# RE : Dart + West+ Project . Reference 314232 . Interested Party not notified and excluded from process.

My Name is Cathleen Herbert and I wish lodge an objection and make observations in relation to the planning application submitted by Dart + West for planning permission for new Railway lines and Depot located between Maynooth & Kilcock. The project in its current form (your application reference 314232) is unacceptable and the application is invalid in so far as it has failed to adhere to the most basic planning regulation and furthermore I want to formally make a request for an Oral hearing.

Drawn By: LA	Checked By: MH	Approved By: MH
Scale: 1:1250 (@A0)	Date: May 2022	
Area No: 039	Plan No: WORKS LAYOUT PLAN NO. WP039

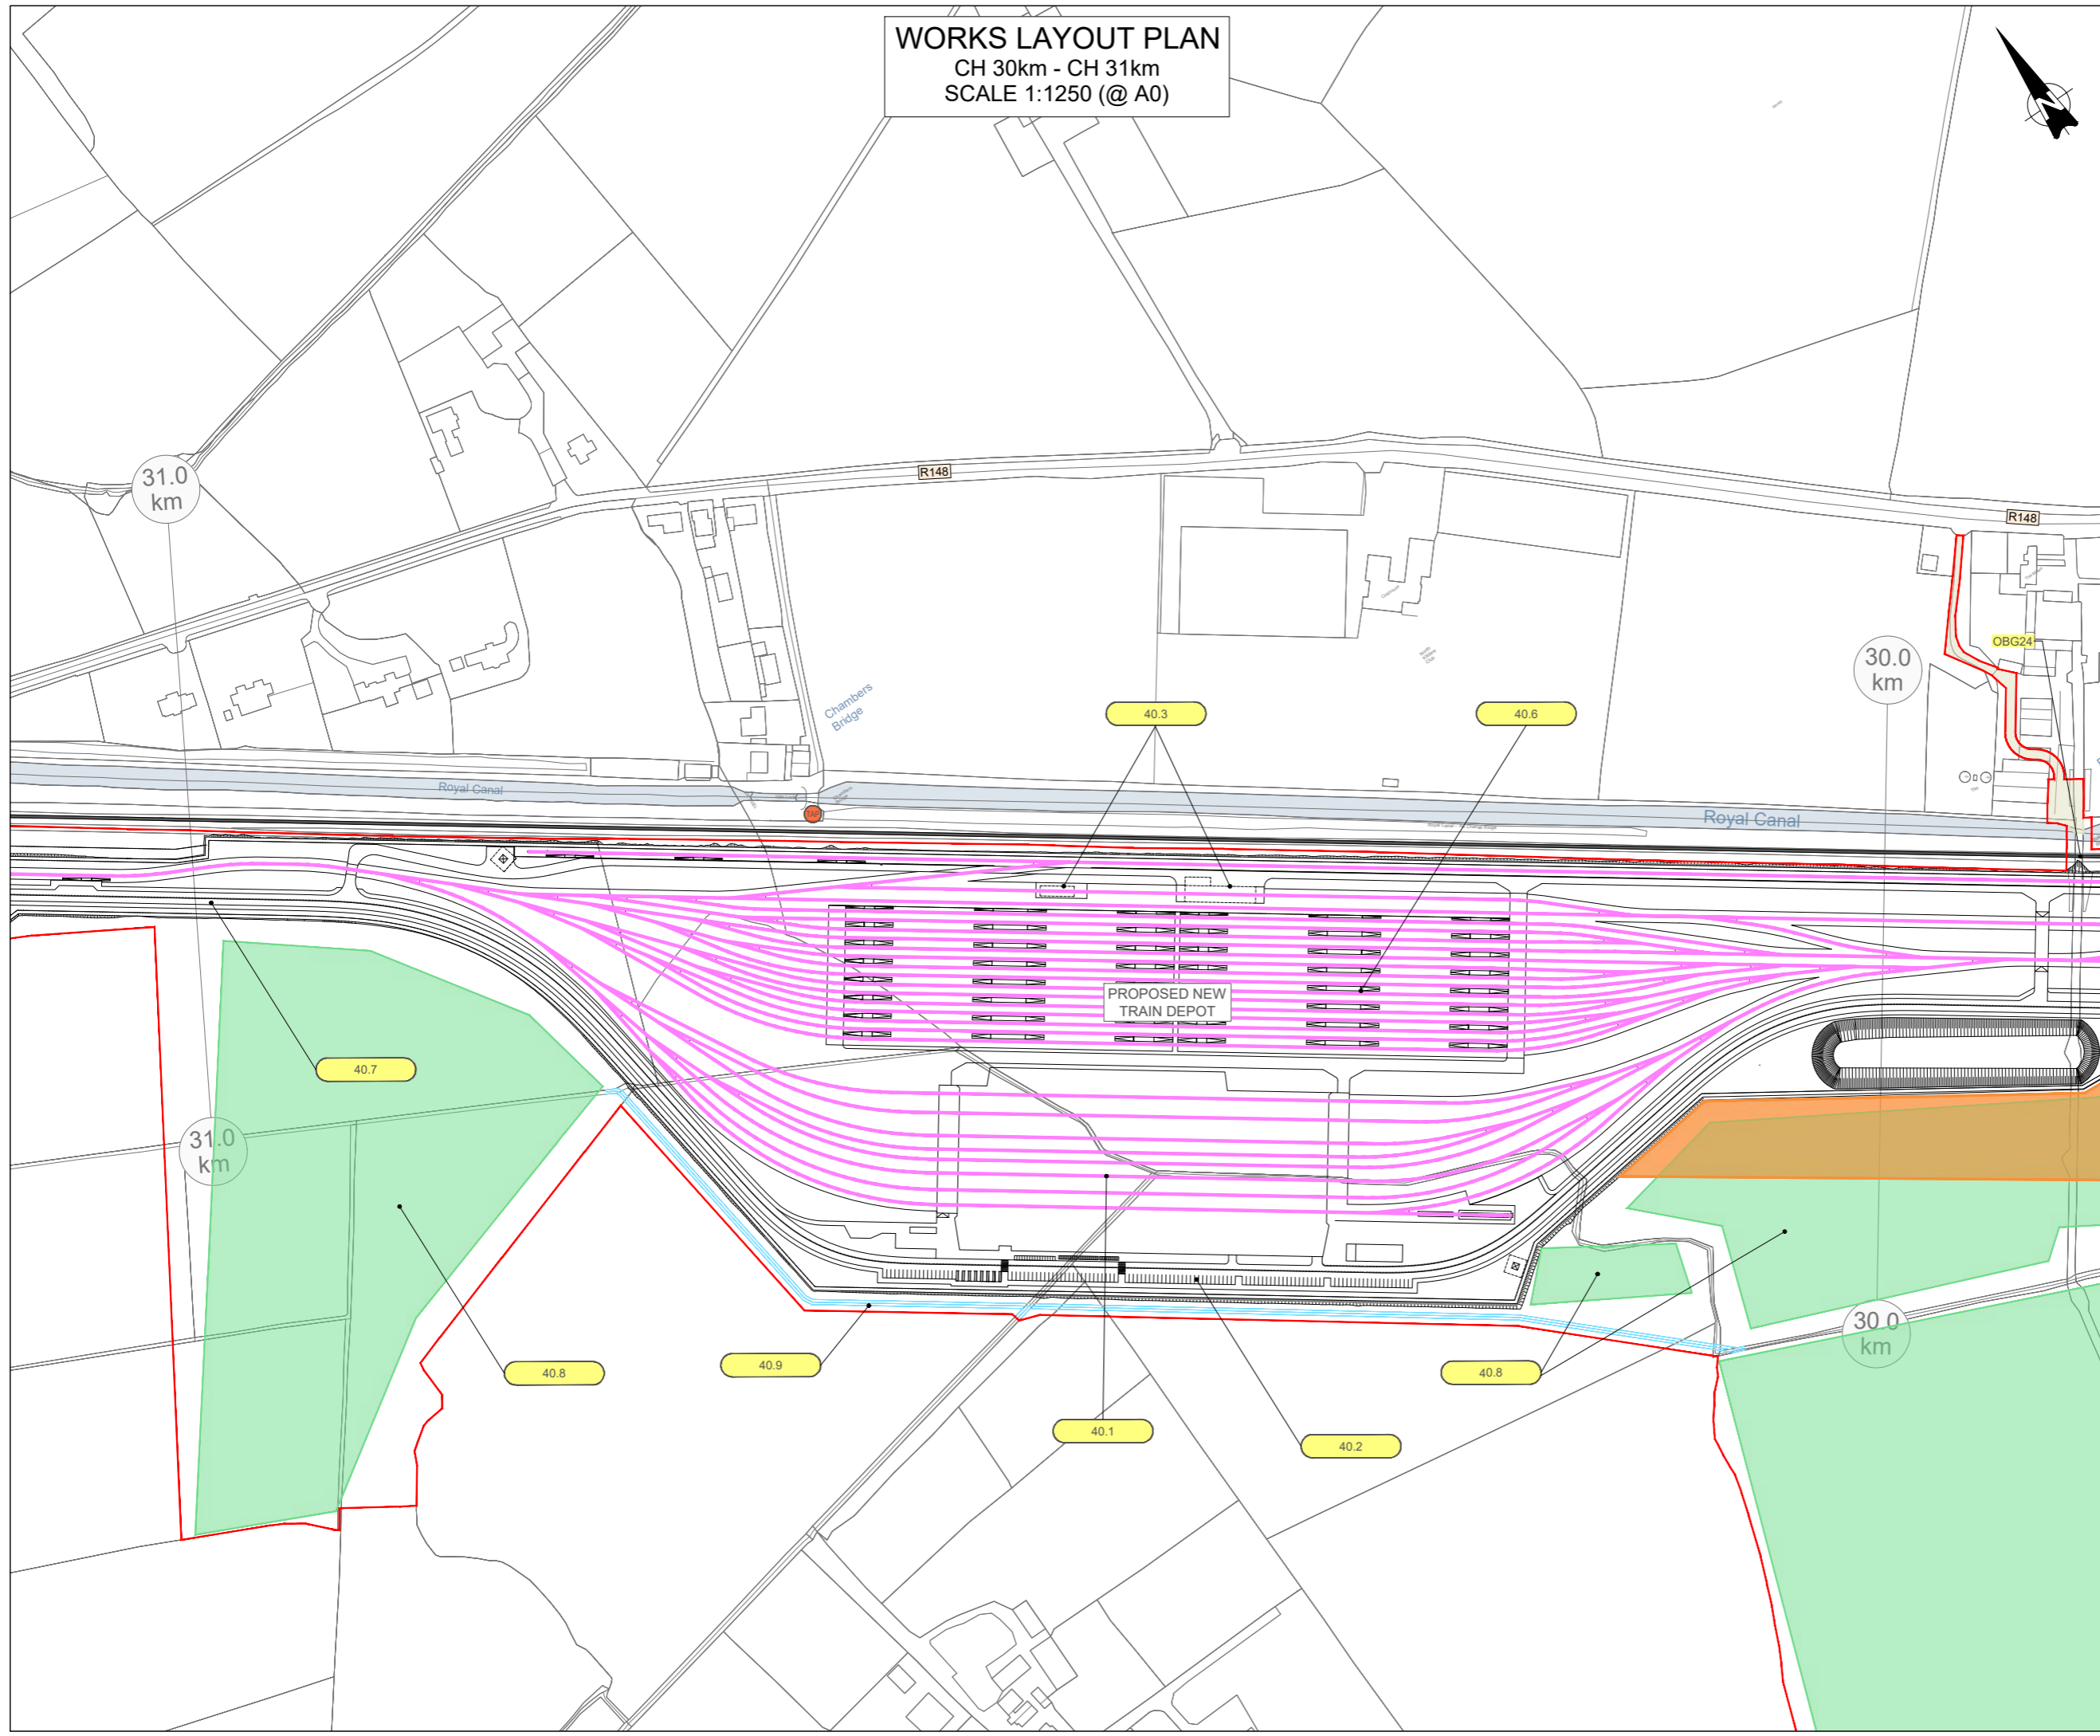
There is also the demolition of the existing bridge OBG24 and the construction of the new bridge OBG23A and a new link road access road from R.148 to the L5041. The road access to the Depot is located adjacent to the Northeast corner of my farm as shown on drawing "Works Layout Plan No WP39,

The entrance roadway to the marshalling yard and the yard tracks are adjacent to my lands. There will be considerable excavation works projected by Irish rail to be 250,000 m3 or 25,000 lorries not to mention the importing of material such as construction material, steelworks, ballast, tracks, and overhead electrification structures. The extract from the book of reference outlines a very large and industrialised construction which will create serious noise and disruption to my animals, my family and my property.

The Depot is offset from the tracks of the main line. The choice of the location of the Depot adjacent to a breeding mare's is unacceptable. The operation facility of the Depot is directly adjacent to my farm. The permanent compound and storage facility for the depot is located directly opposite my house and farm as is the proposed new link road and new bridge.
